Our ref: HA/2014/115552/01-L01
Your ref: AB/130/13
Date: 24 April 2014

**CHANGE OF USE AND EXTENSION TO CREATE 3NO. SELF CONTAINED APARTMENTS AND 1NO. MAISONETTE. THIS APPLICATION AFFECTS THE CHARACTER AND APPEARANCE OF ARUNDEL CONSERVATION AREA
ARDEN GUEST HOUSE 4 QUEENS LANE ARUNDEL BN18 9JN**

Job Title	Arden Guest House	
Client	Mr & Mrs Meathrel	
Drawing Name	Proposed Ground Floor Plan	
Drawing Status	Planning	
Drawn by	DF	Date Dec 13
Checked by		Date
Drawing Scale	1:50 at A2	
Drawing No	Status	Revision
13519/ 05

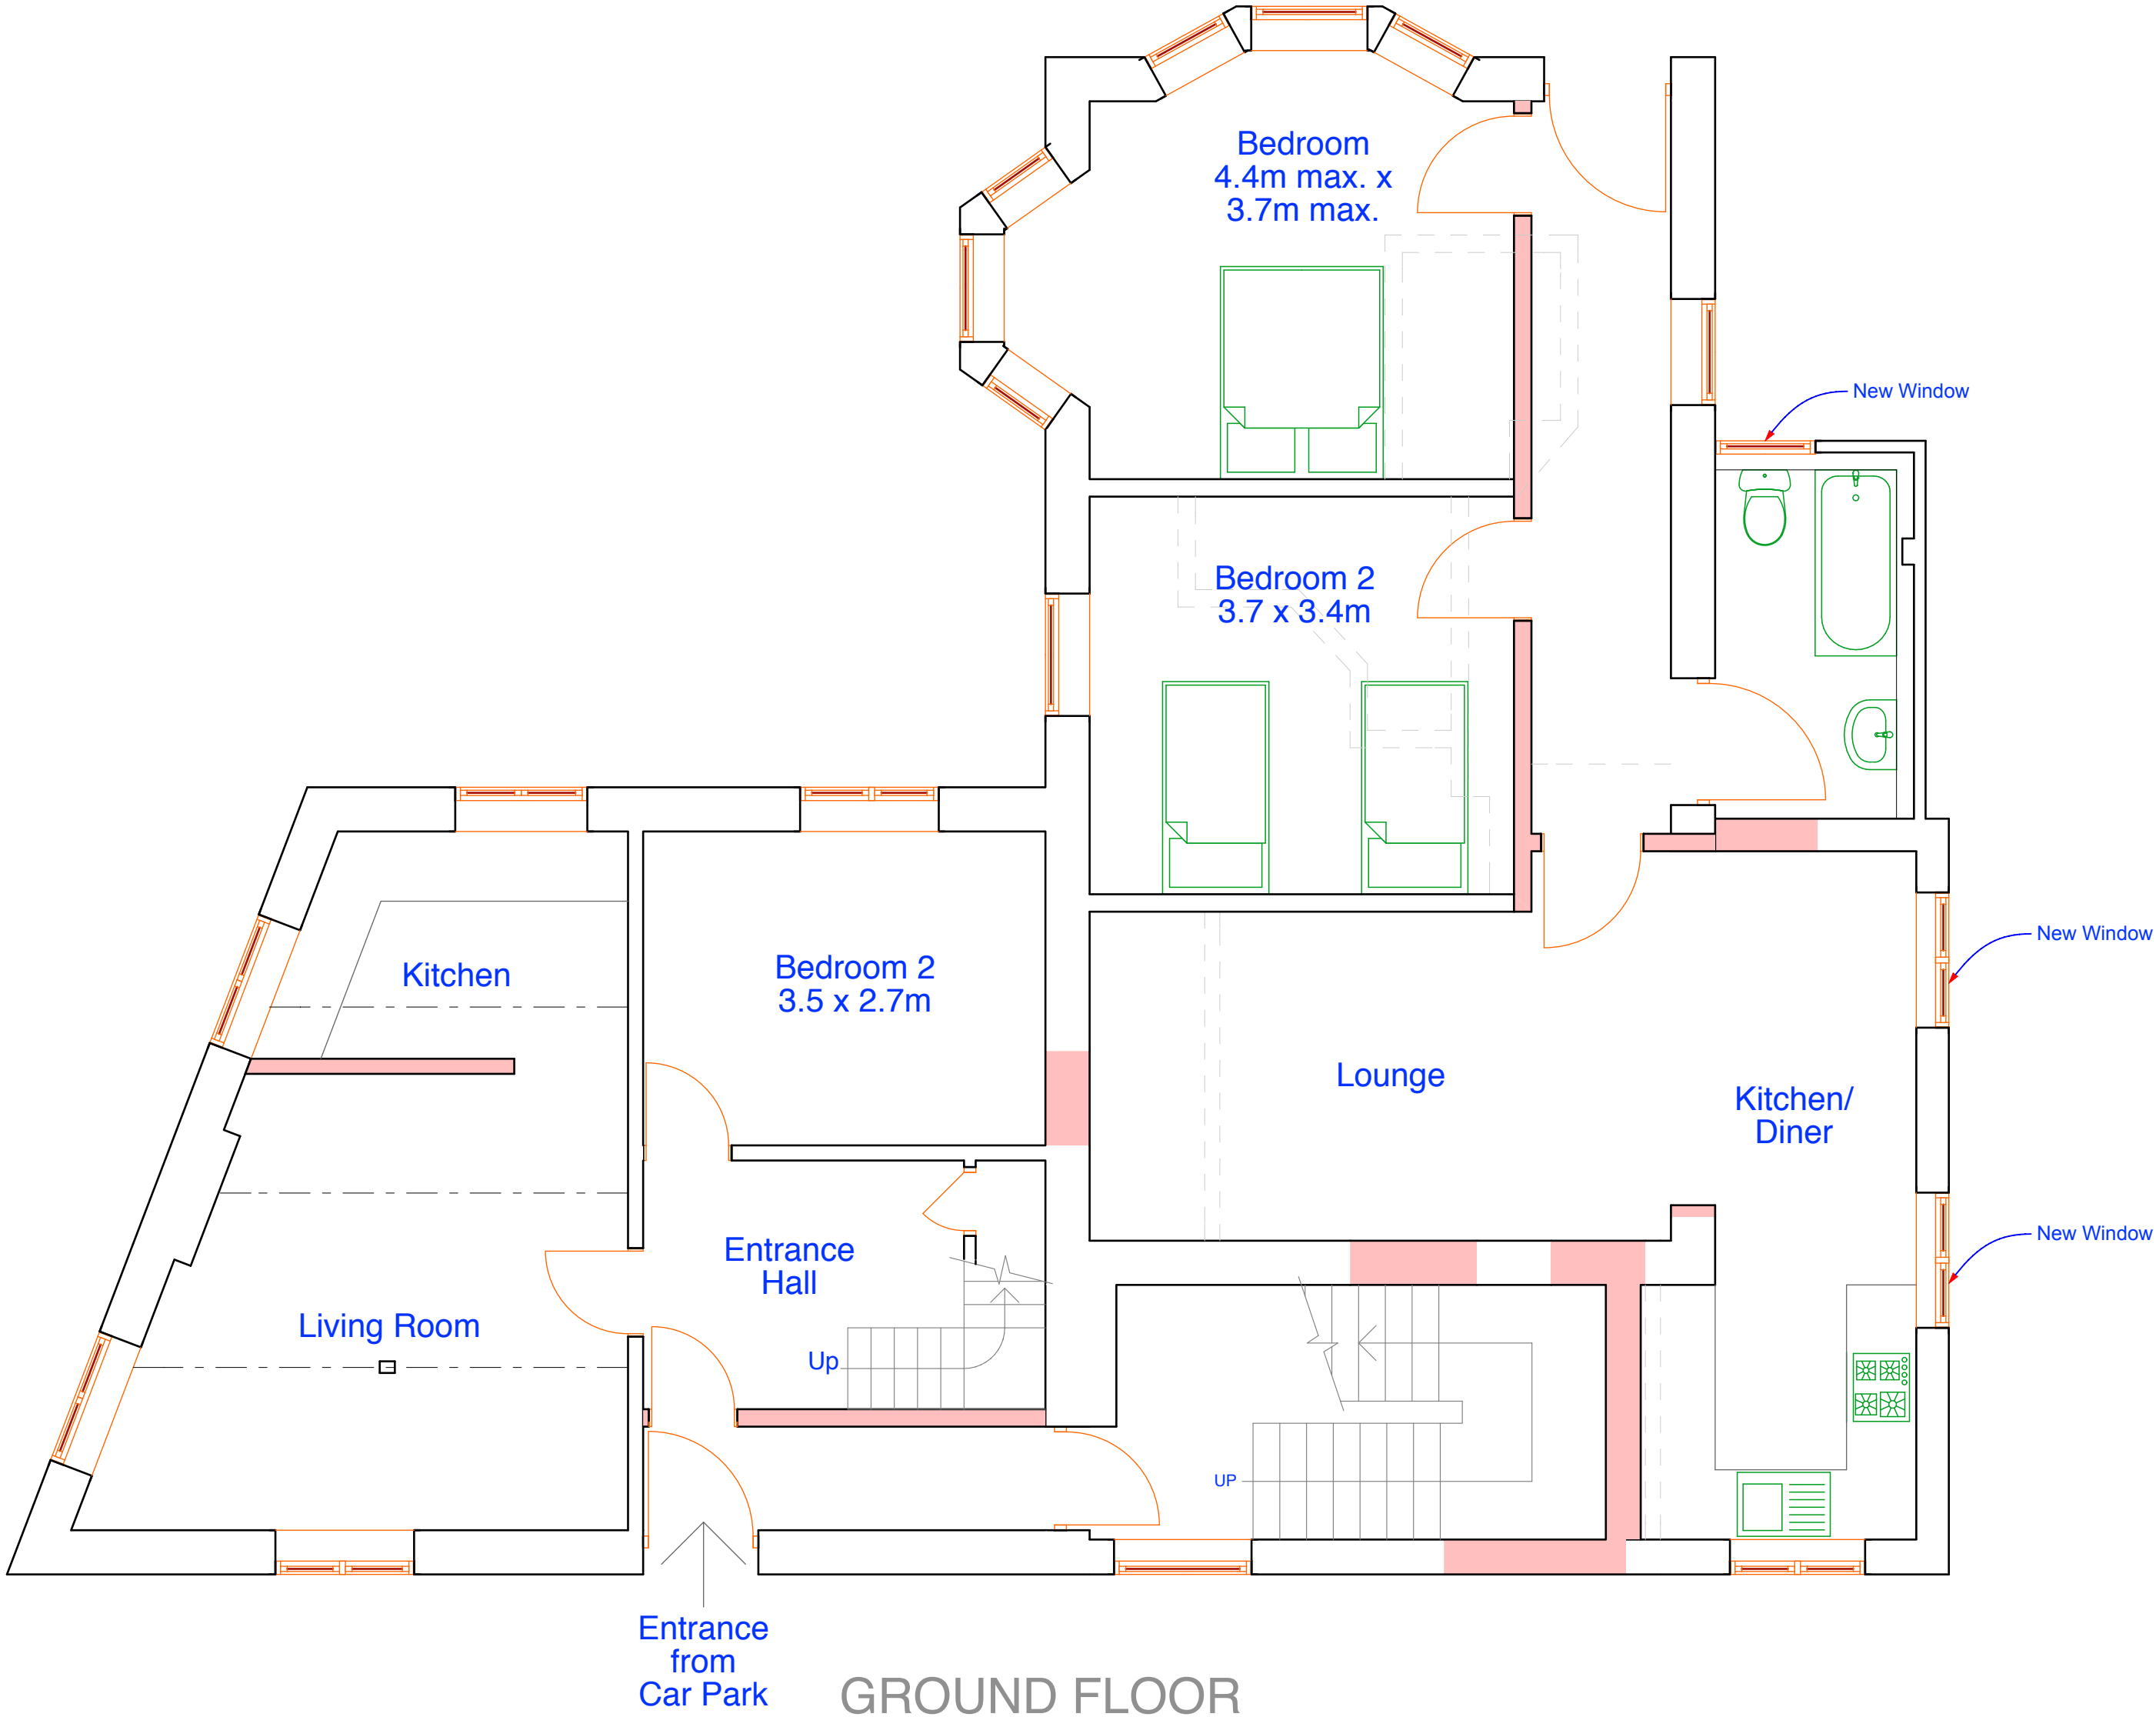
We have concerns whether this can be achieved in relation to the proposed ground floor self contained apartment.
